# ENG-CDR21014-R2-GEC.pdf Markup Summary

**Subject:** SW - Textbox with Arrow  
**Page Index:** 4  
**Date:** 2/9/2022 10:58:54 AM  
**Author:** EPC Stormwater - Glenn Reese  
**Color:** ■  
**Layer:**  
**Space:**  
**Page Label:** [5] 5 INTERIM EROSION CONTROL PLAN

INTERIM EROSION
CONTROL PLAN

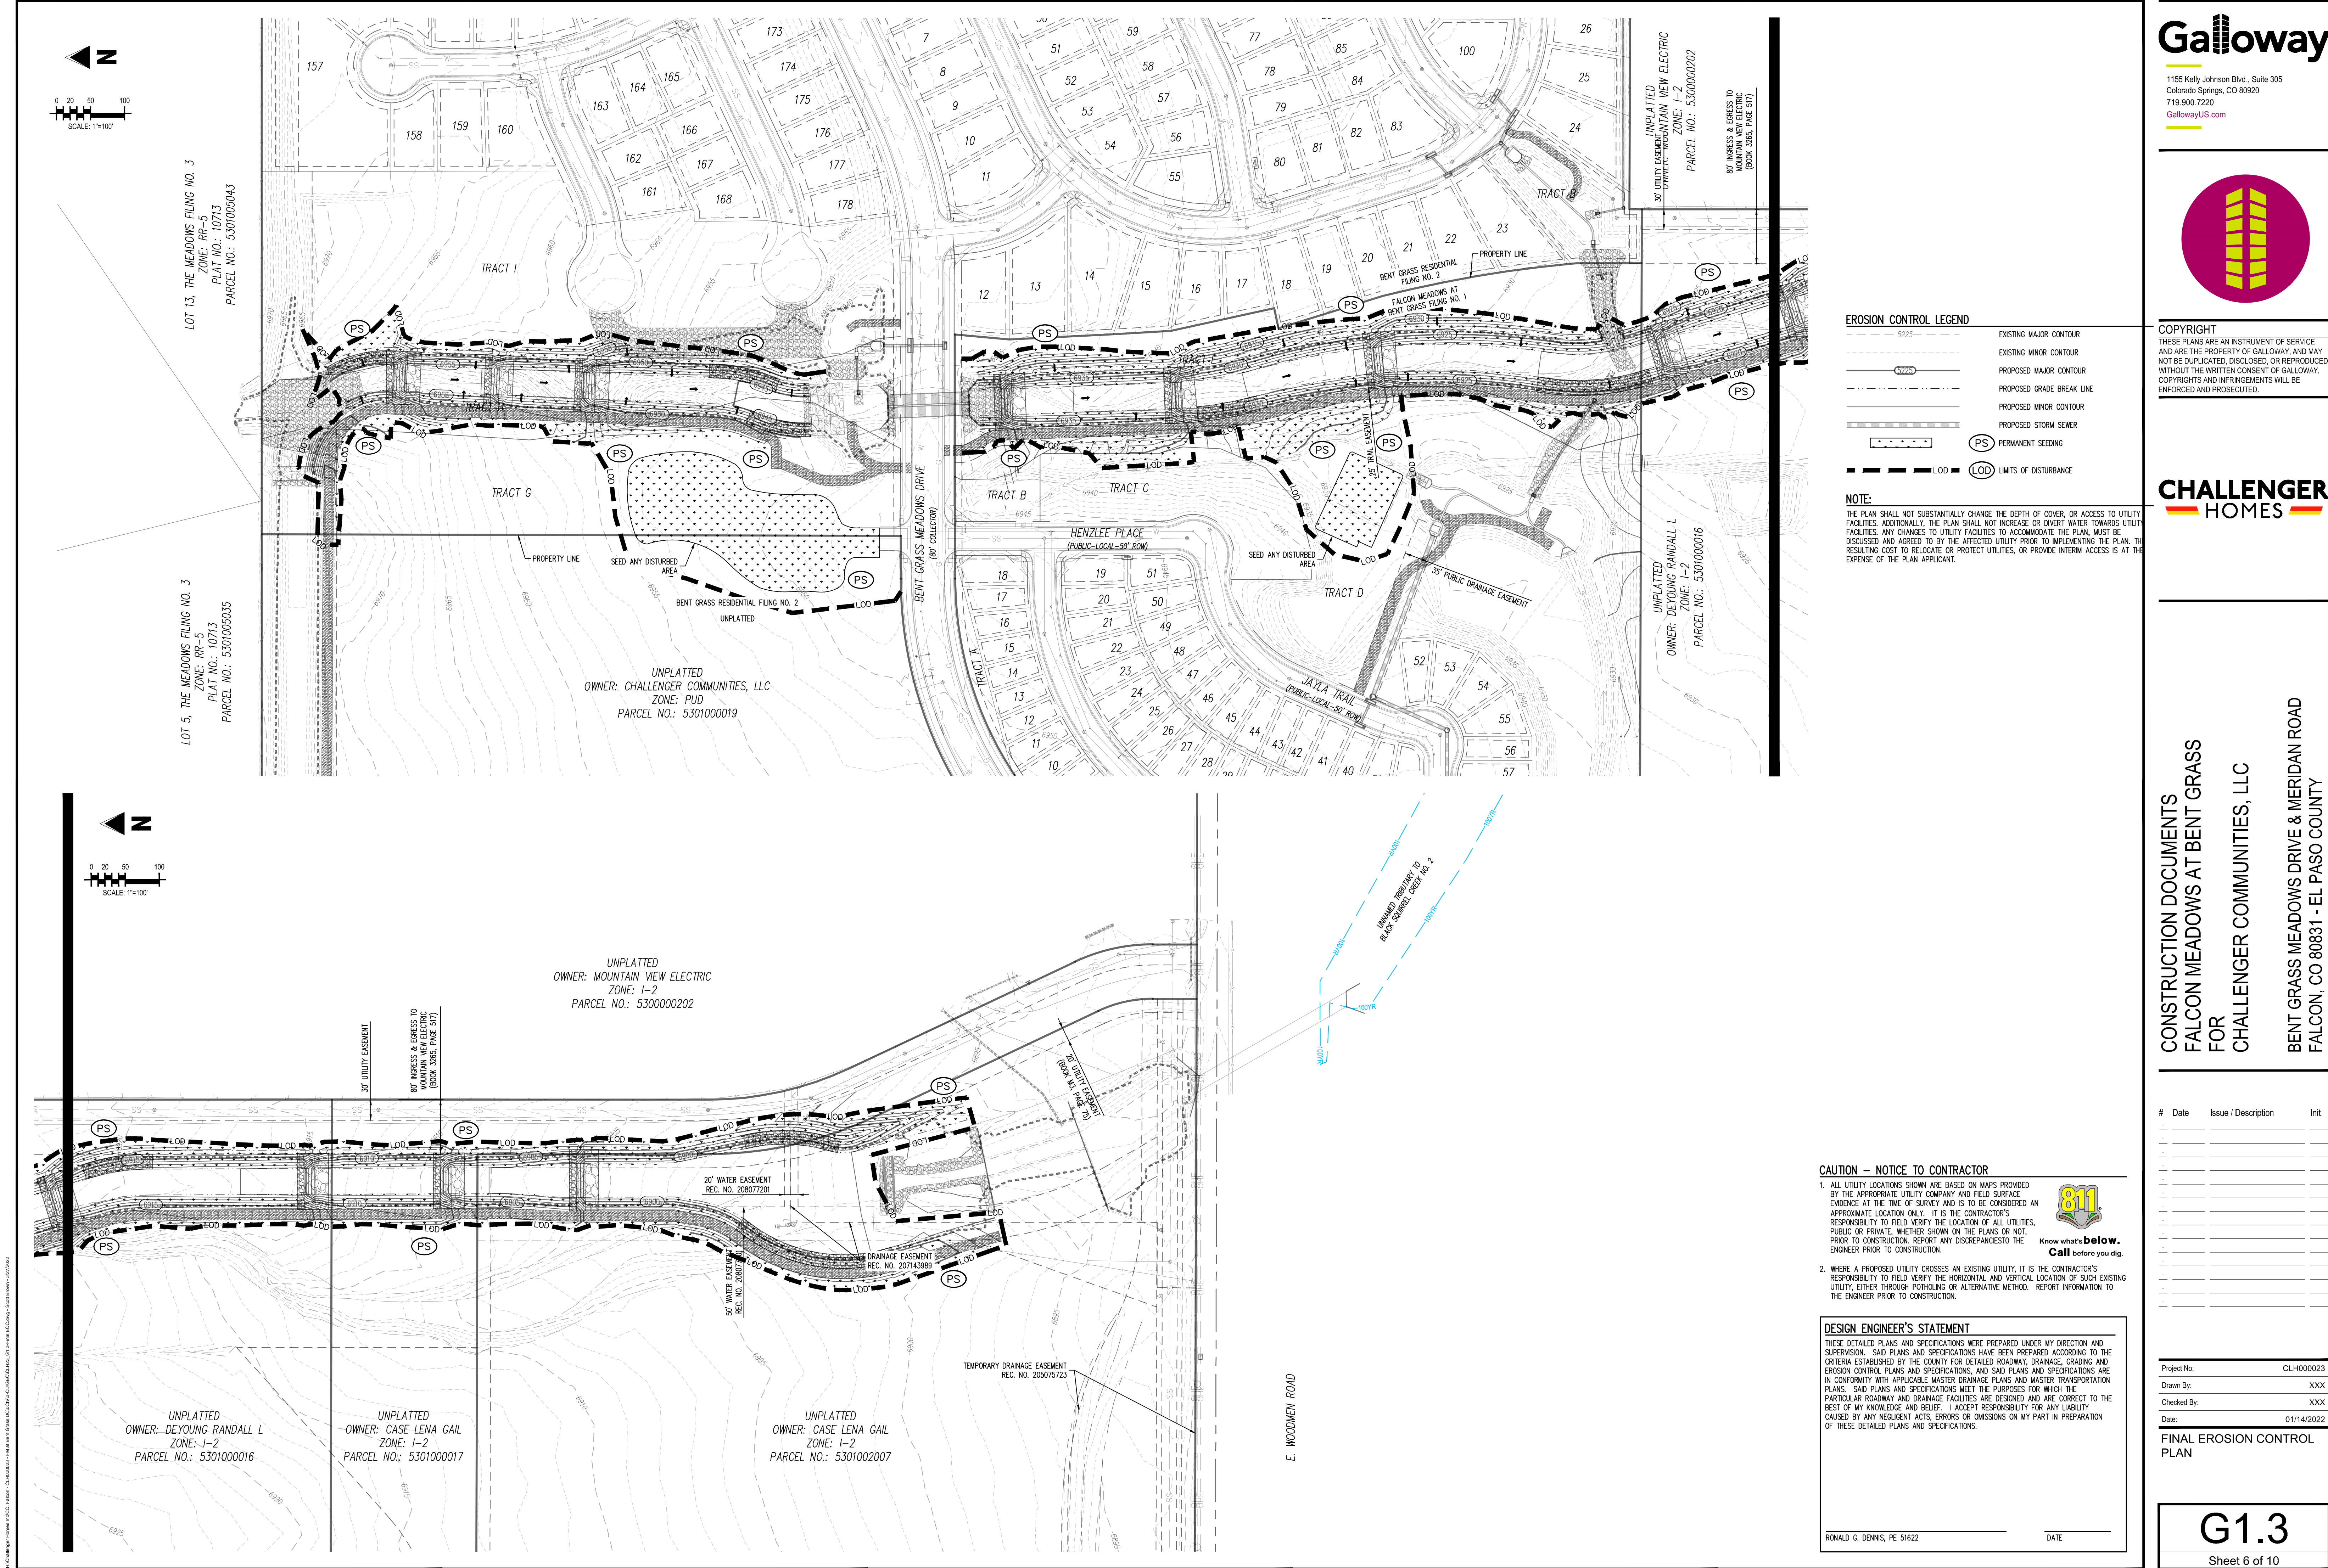
SL is not an appropriate BMP within a major drainageway such as this. They will likely be washed downstream during a decent runoff event. Consider using a different BMP here or none at all.

Figure VT-2
Vehicle Tracking
Application Examples

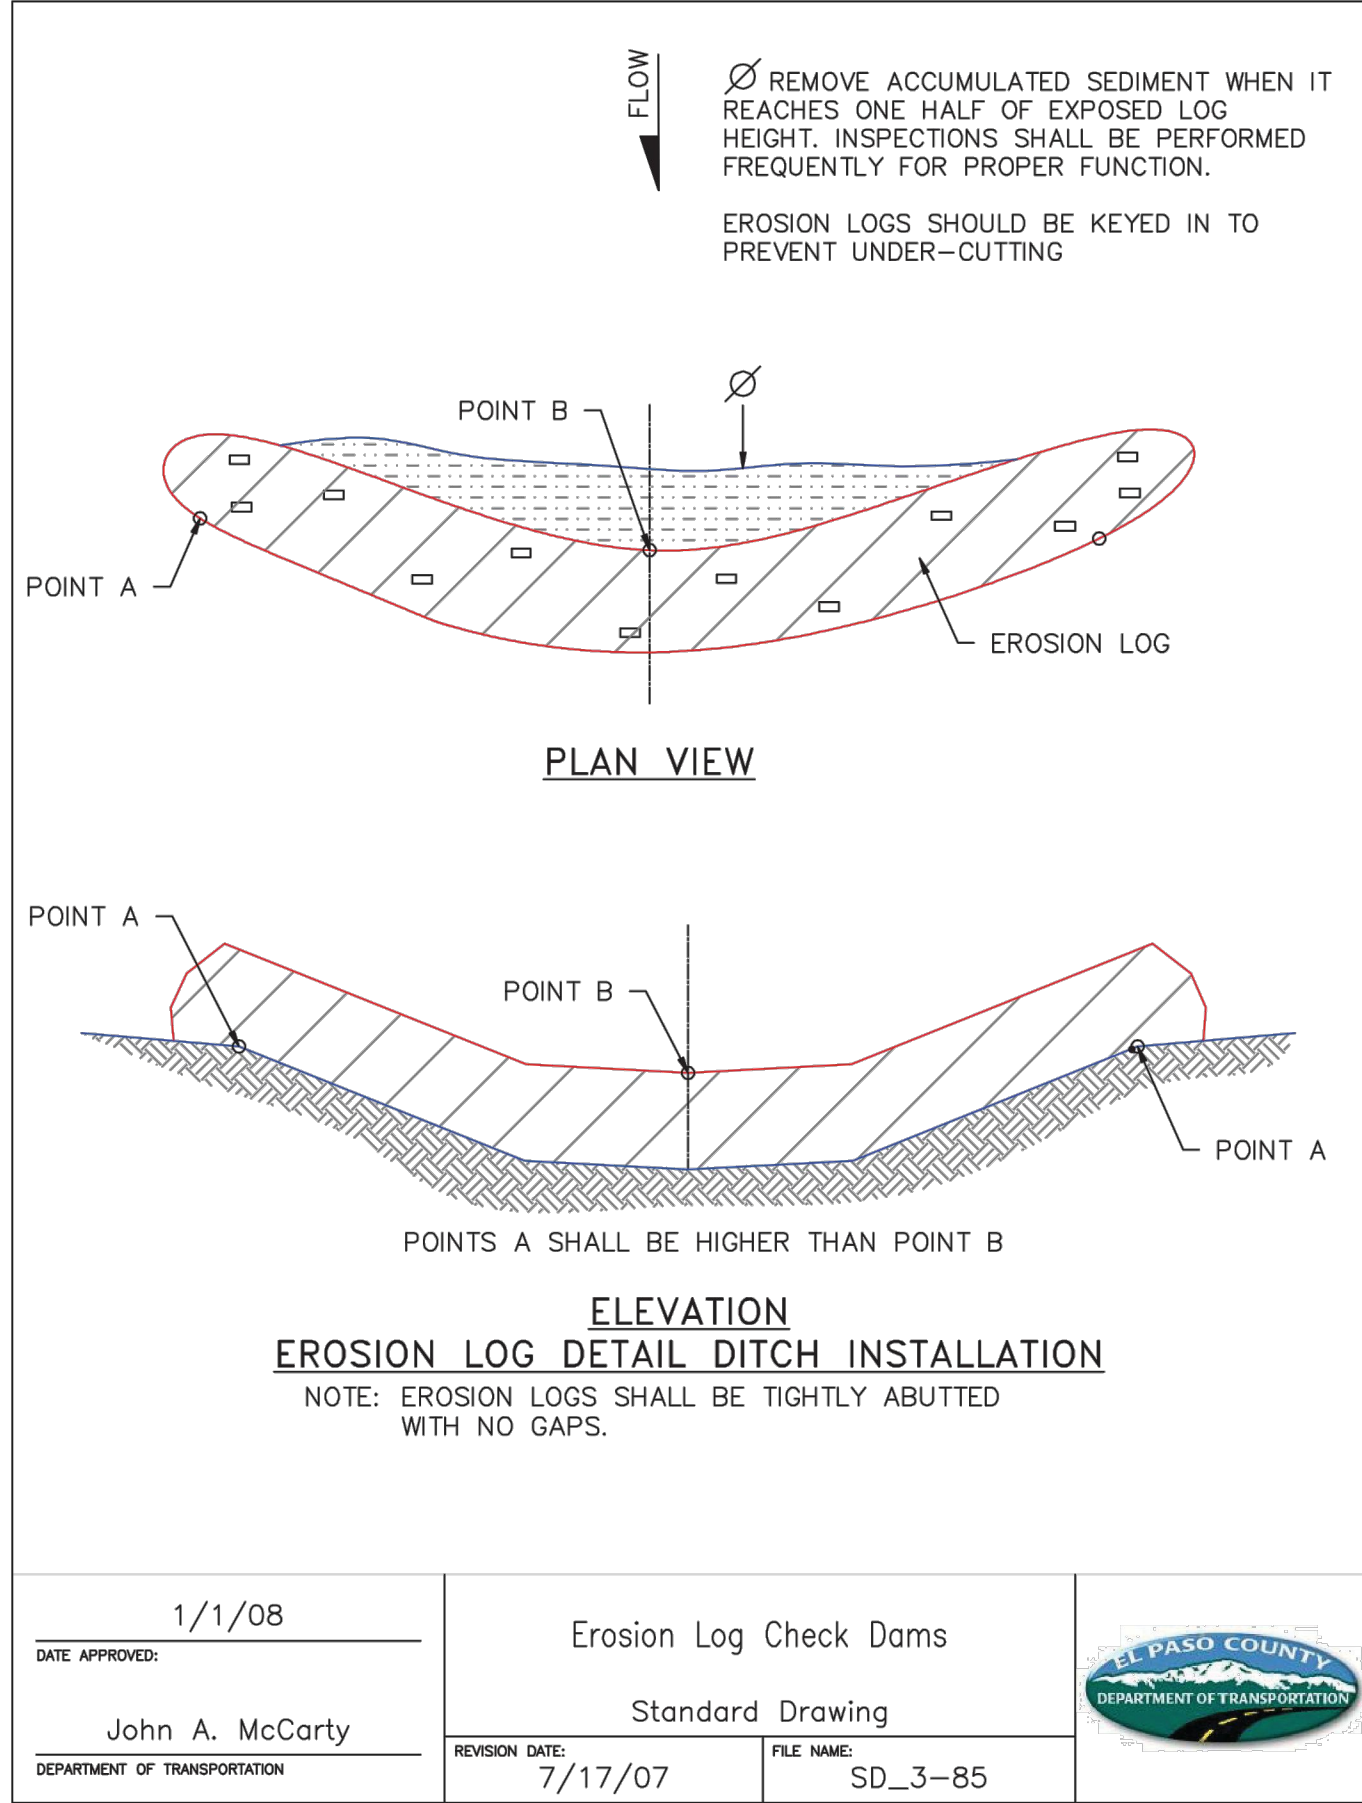
Unresolved comment:  
 replace with EPC approved VTC detail (VT-1 and VT-2 in DCMv2, Chap 3.3) or revise to be 75ft min length.
